# **East Anglia TWO Offshore Windfarm**

## **Applicant's Response to AONB Partnership submissions:**

**Reports by Alison Farmer Associates**

Applicant: East Anglia TWO Limited  
Document Reference: ExA.AS-6.D4.V1  
SPR Reference: EA2-DWF-ENV-REP-IBR-001169

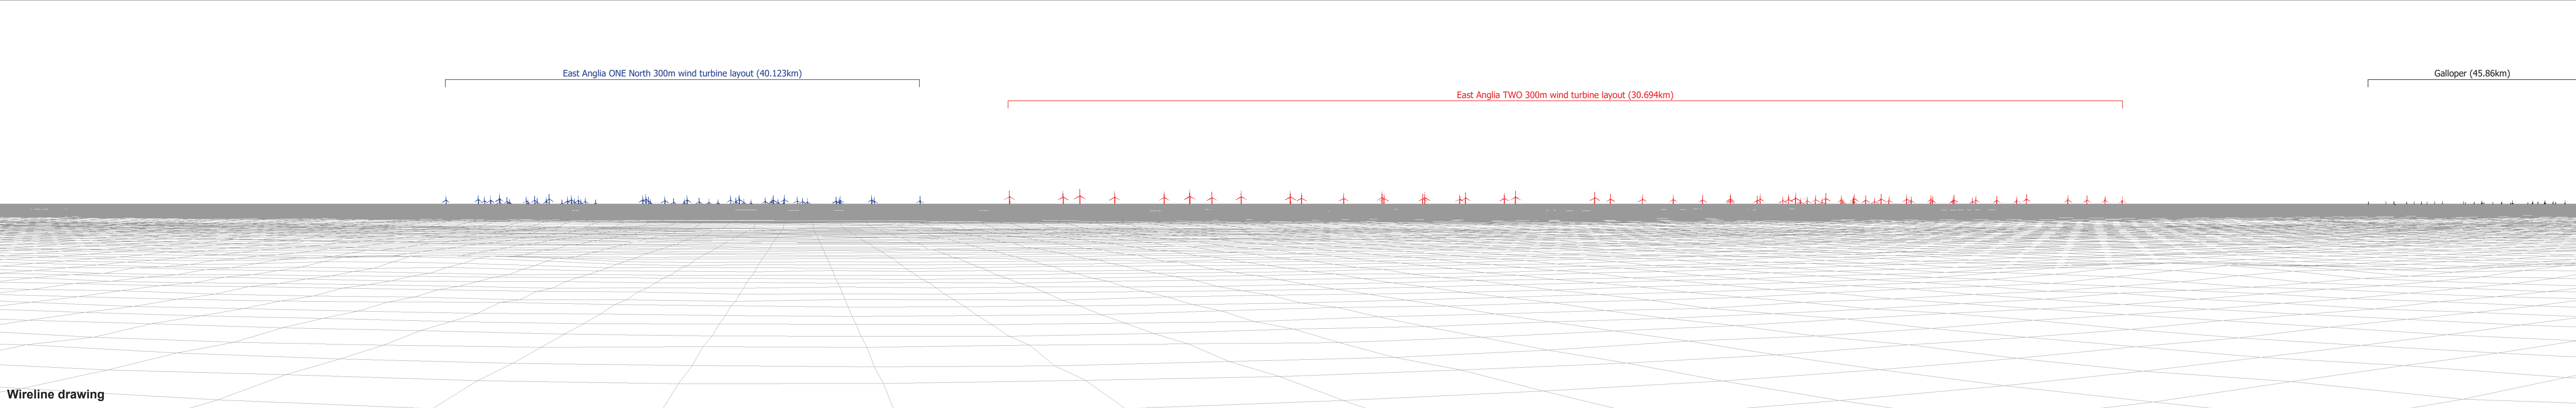
| Point ref. | AFA Summary point  | Applicants' Comments  |
|------------|--|---|
| 2.2.1      | Viewpoints 3 to 18 fall within the AONB. Using the data in Table 28.3 of the ES chapter 28, I have set out below the differences between the PIER and mitigated schemes in relation to distance from the nearest turbine and horizontal angle of view occupied by the scheme for each viewpoint. | <p>Whilst the information presented in the table may be accurate for the nearest turbines shown in the PEIR and ES viewpoint wirelines the differences shown do not reflect the changes in distance of the Array Area boundary to the viewpoint. Due to the Rochdale Envelope approach to the assessment the WTGs may be located anywhere within the defined Array Area.</p> <p>This comparative information is set out in the ES at Table 28.3 Comparison between distance and horizontal angle of East Anglia TWO windfarm PEIR layout and ES layout from representative viewpoints in Suffolk.</p> |

| Point ref. | AFA Summary point  | Applicants' Comments  |
|------------|--|---|
| 2.2.2      | The table above shows that of the viewpoints within the AONB, the nearest turbine will be further away for just 5 of them (viewpoints 3-6 and 17). For the other 11 viewpoints (viewpoints 7-16 and 18) the nearest turbine will become closer in the mitigated proposals. The greatest difference occurs in relation to viewpoints 3 and 4 (where distance will increase by over 1km). However, all of these differences are relatively minor and are not readily perceived, as such they are unlikely to result in a material difference in effects.   | <p>The Applicant agrees that in isolation differences in the distances from each viewpoint are unlikely to materially alter the effects.</p> <p>However, the Applicant notes that the increased distance is only one of the resulting factors of the mitigation with the reduced field of view affected by East Anglia TWO always being apparent at the same time. These factors would not be seen in isolation and it is their combined effect that should be considered.</p>  |

<table><tr><th colspan="8">Percentage of horizon affected in a 90 degree horizontal field of view</th></tr><tr><td>3</td><td>43</td><td>29</td><td>18.4</td><td>8</td><td>14</td><td>55</td><td>47.4</td></tr></table>

Figure: 28.57b
Viewpoint 4: Southwold

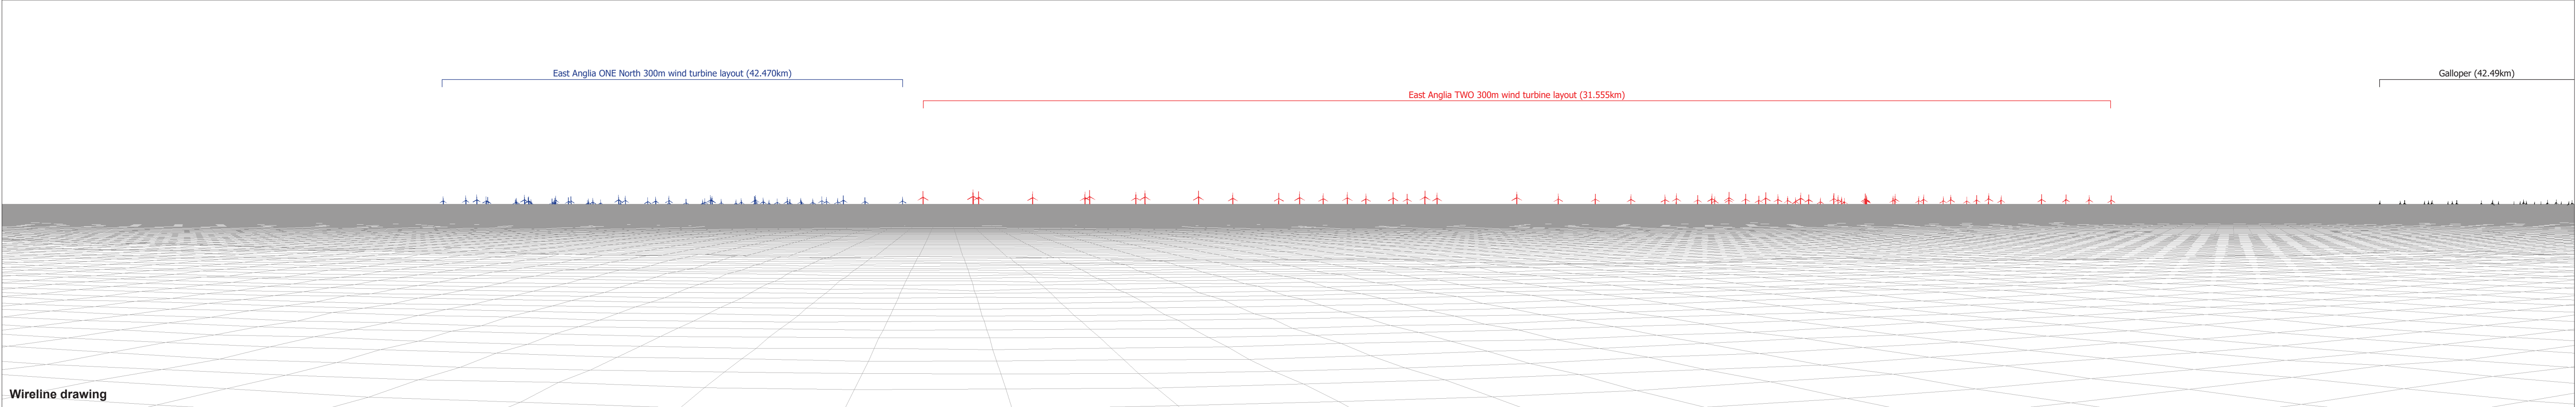
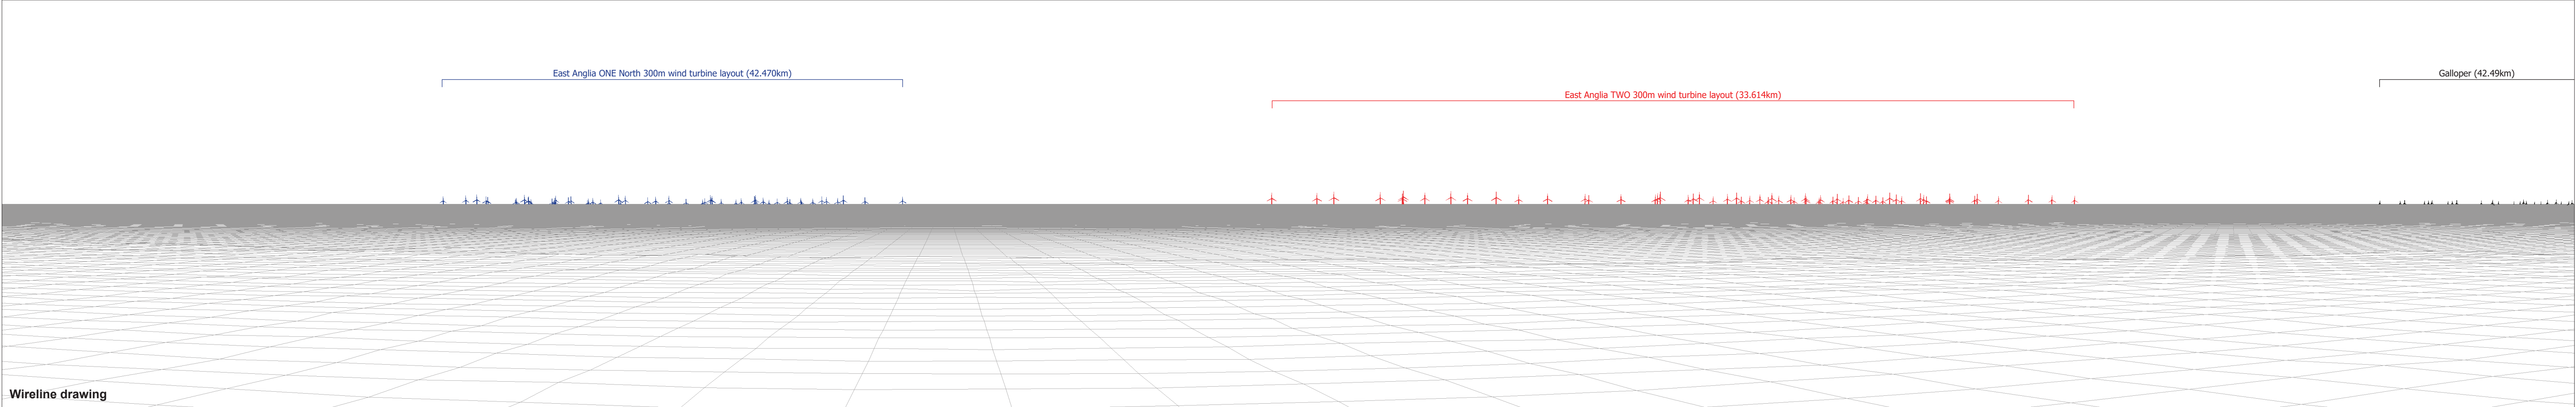
<table><tr><th colspan="8">Percentage of horizon affected in a 90 degree horizontal field of view</th></tr><tr><td>4</td><td>46.3</td><td>31</td><td>18</td><td>7.6</td><td>15.2</td><td>57</td><td>49</td></tr></table>

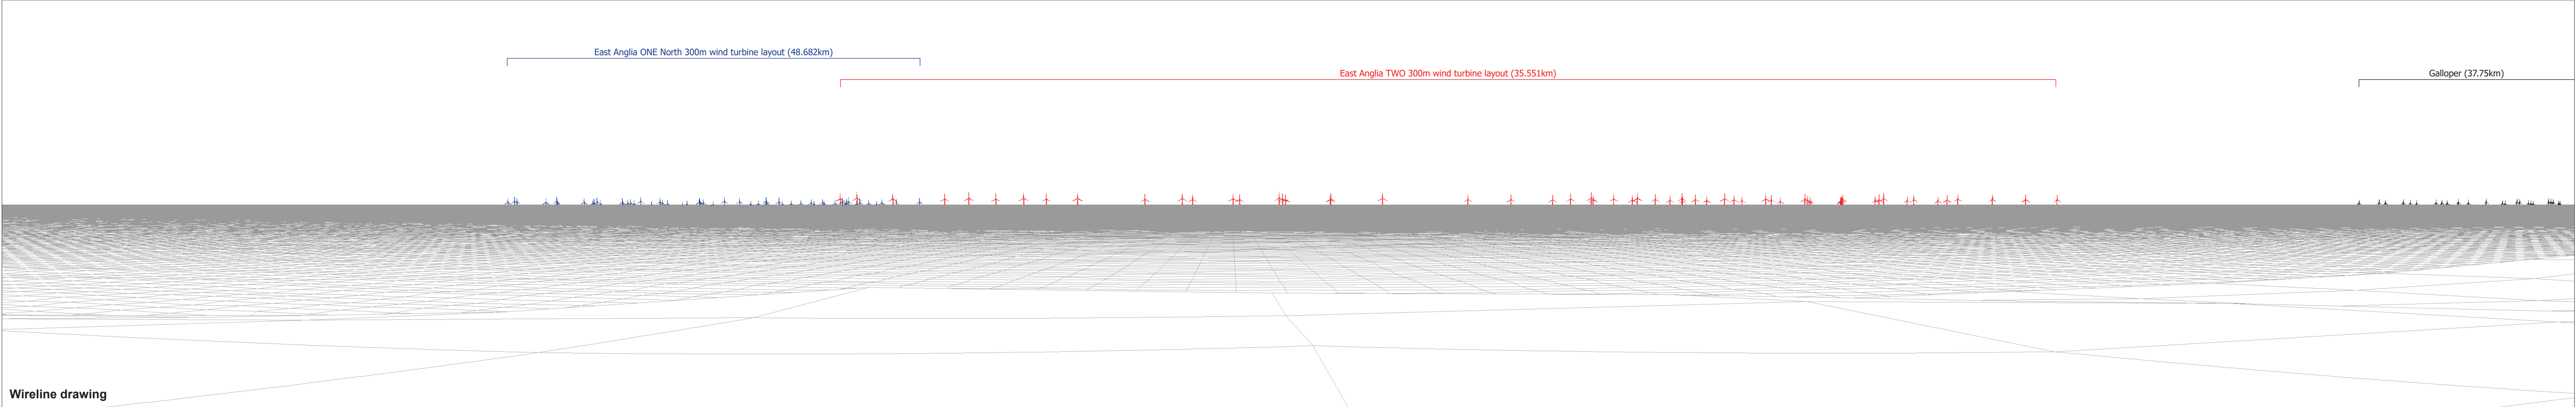
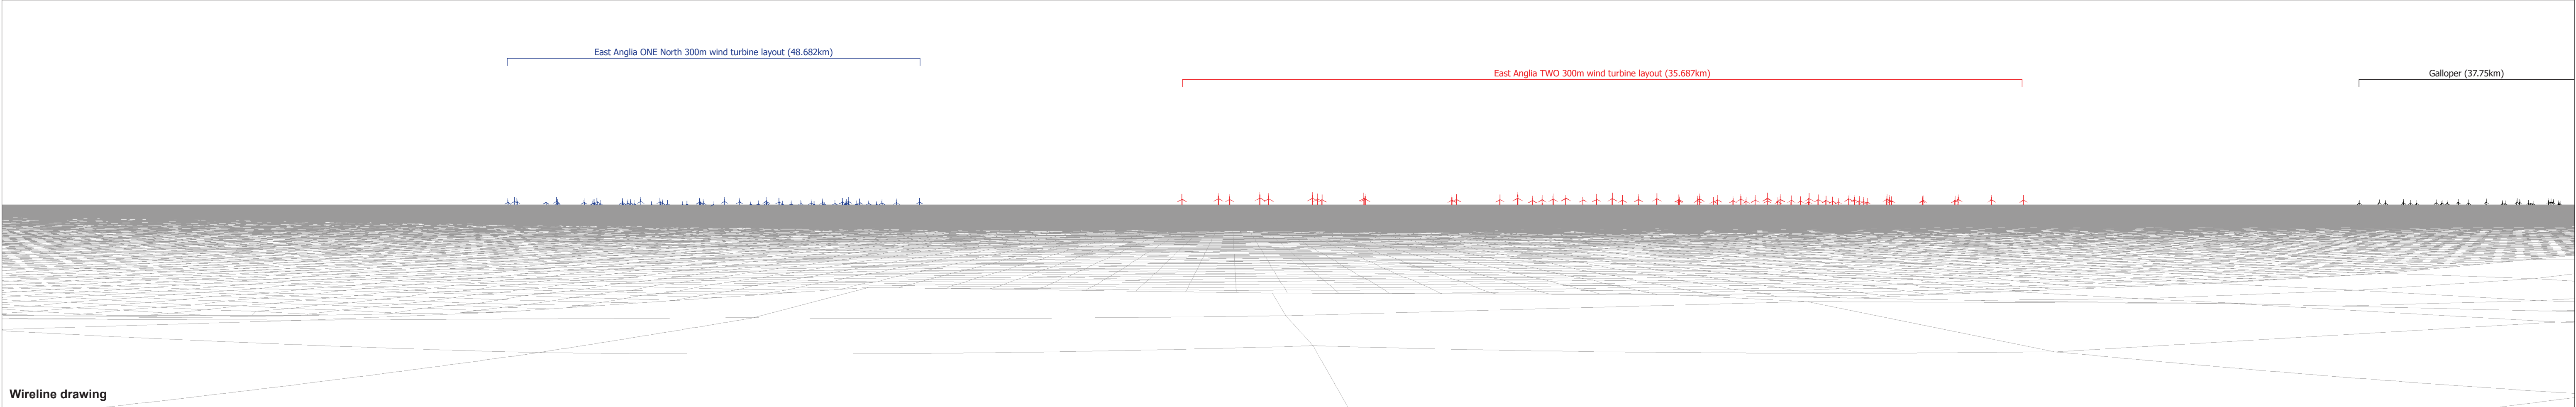
<table><tr><th colspan="8">Percentage of horizon affected in a 90 degree horizontal field of view</th></tr><tr><td>8</td><td>47.4</td><td>32.6</td><td>16</td><td>8.3</td><td>14.7</td><td>57</td><td>48</td></tr></table>

Figure: 28.60a
 Viewpoint 18: Orfordness (eastern shore, pagodas)

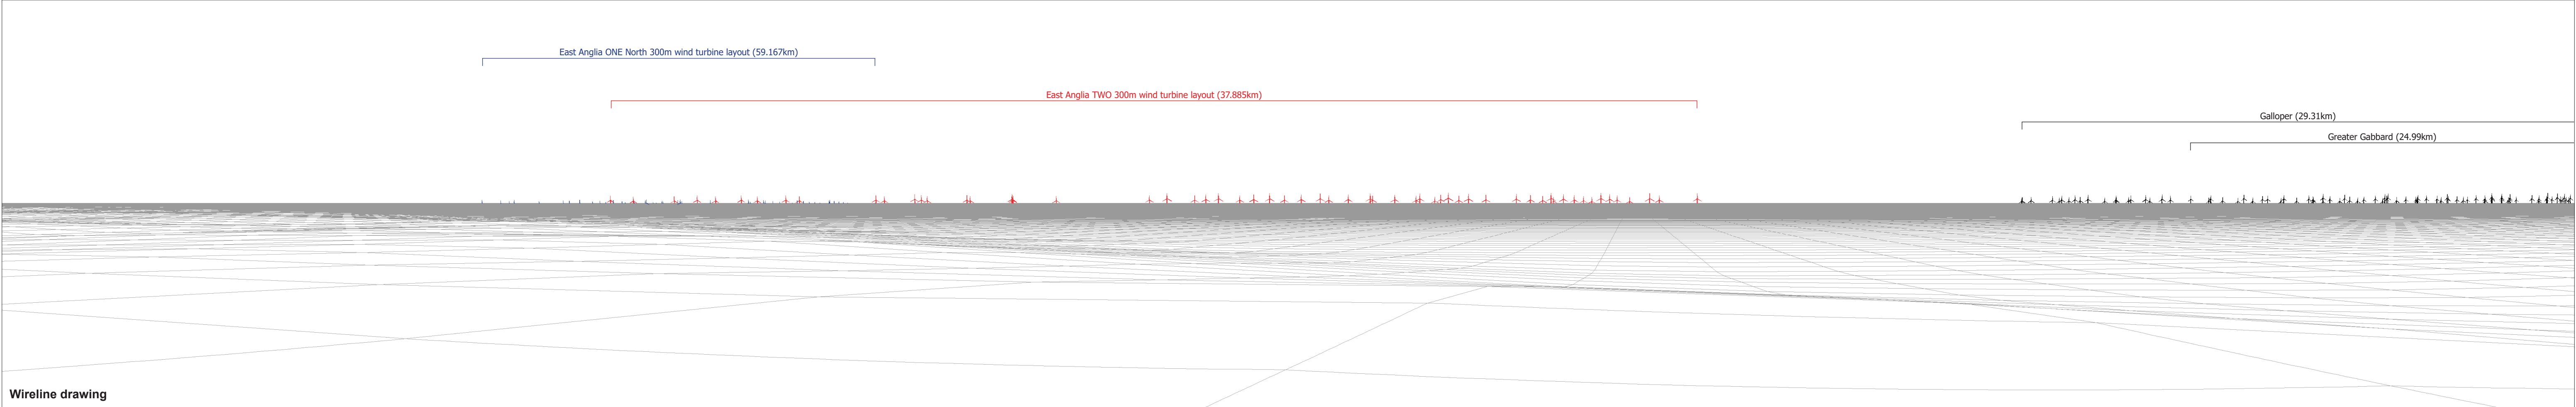
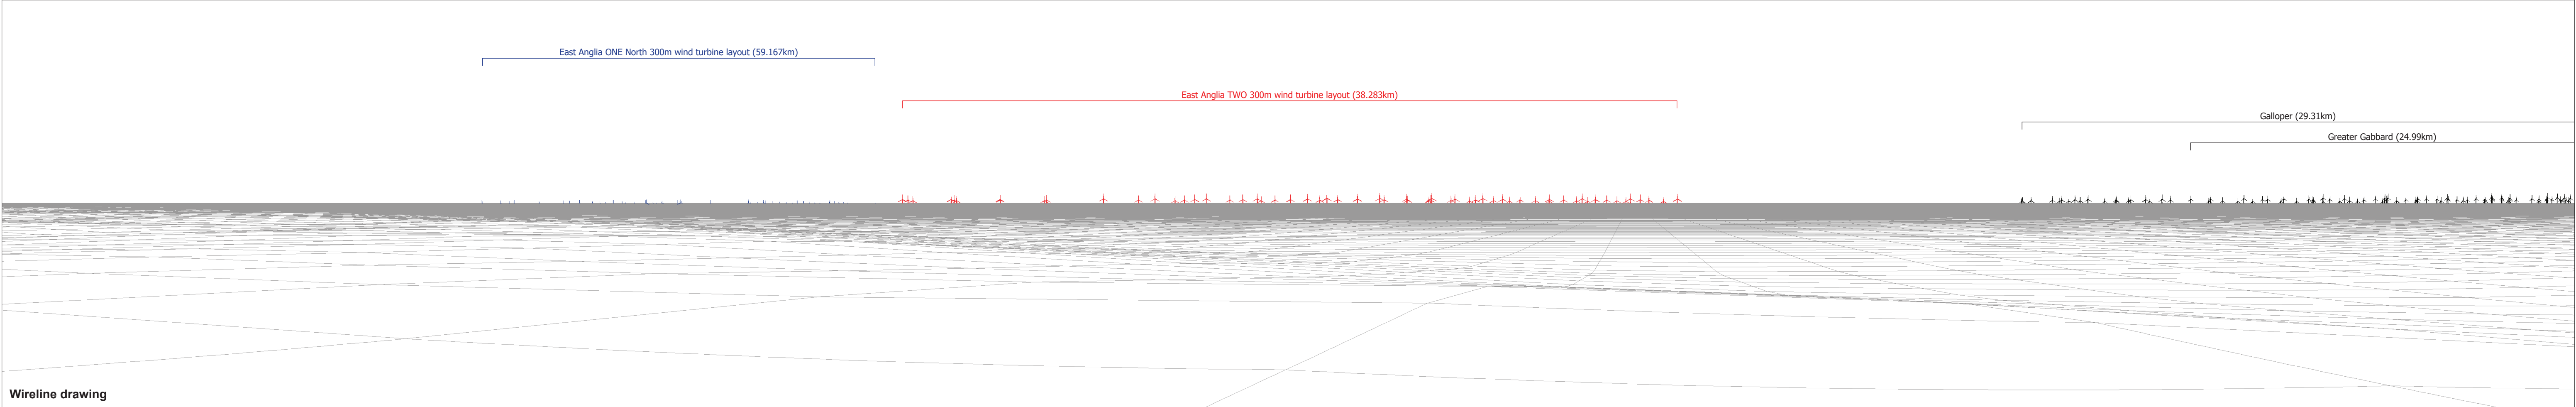
<table><tr><th colspan="8">Percentage of horizon affected in a 90 degree horizontal field of view</th></tr><tr><td>18</td><td>42.3</td><td>30.2</td><td>15.3</td><td>21.4</td><td>12.1</td><td>70</td><td>51.6</td></tr></table>
